Our Ref: P/20/10/

Garage construction 5m x 5m with pitched roof matching existing bungalow in appearance.

51 Harbour Road Bognor Regis

Thank you for your internet comments made on 31st March 2010 and recorded as follows:

Sheet No: 2 of 3

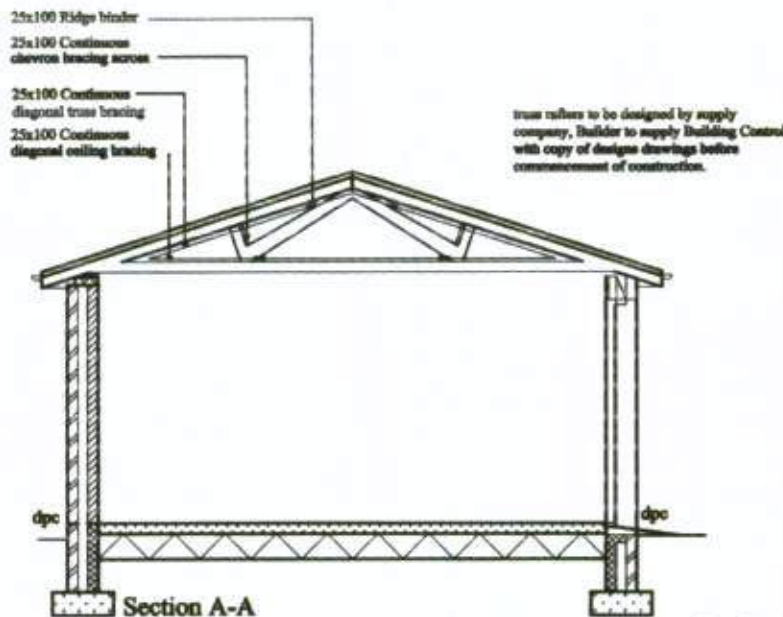
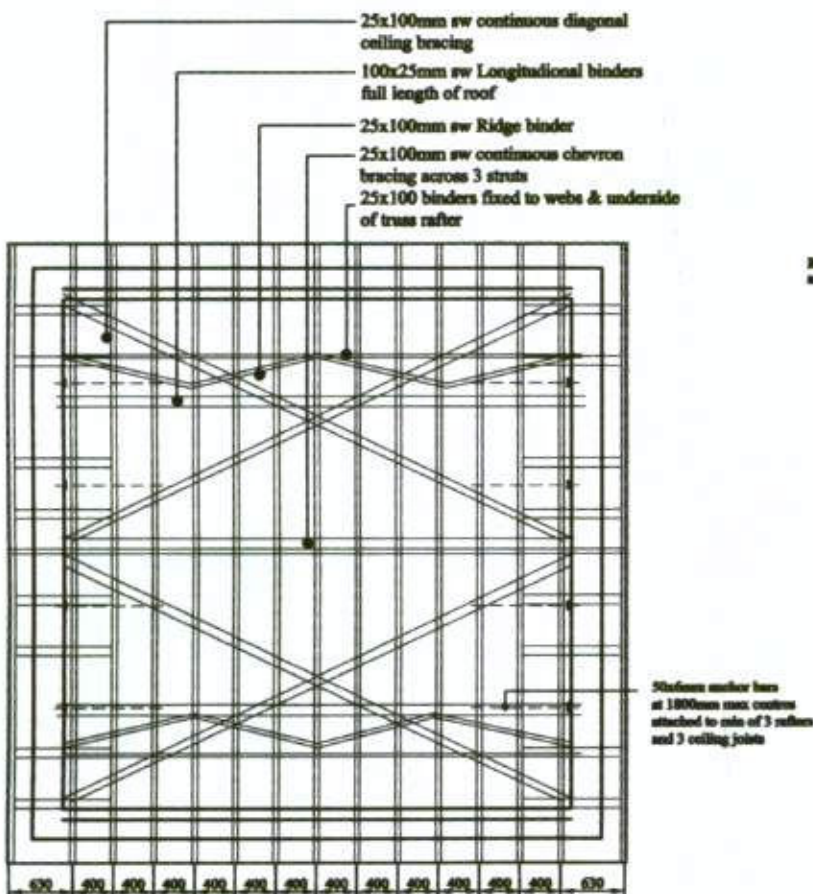
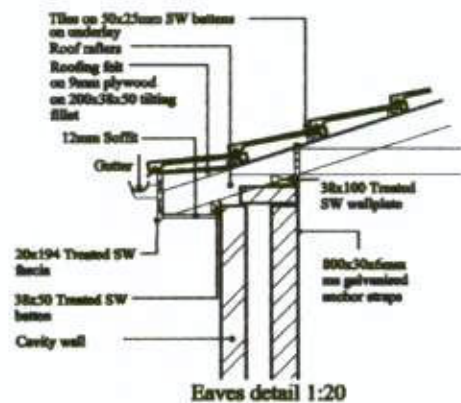
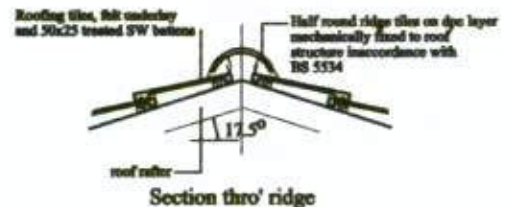
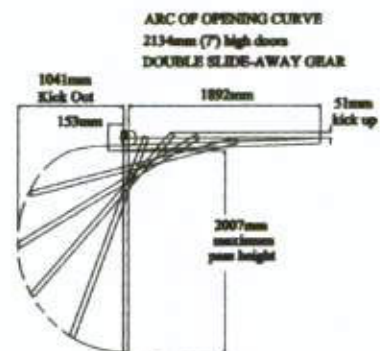
In principle Members were content to approve this application as a garage. However Members noted the cavity walls and the high level of roof insulation which they felt was somewhat unusual for a garage construction.
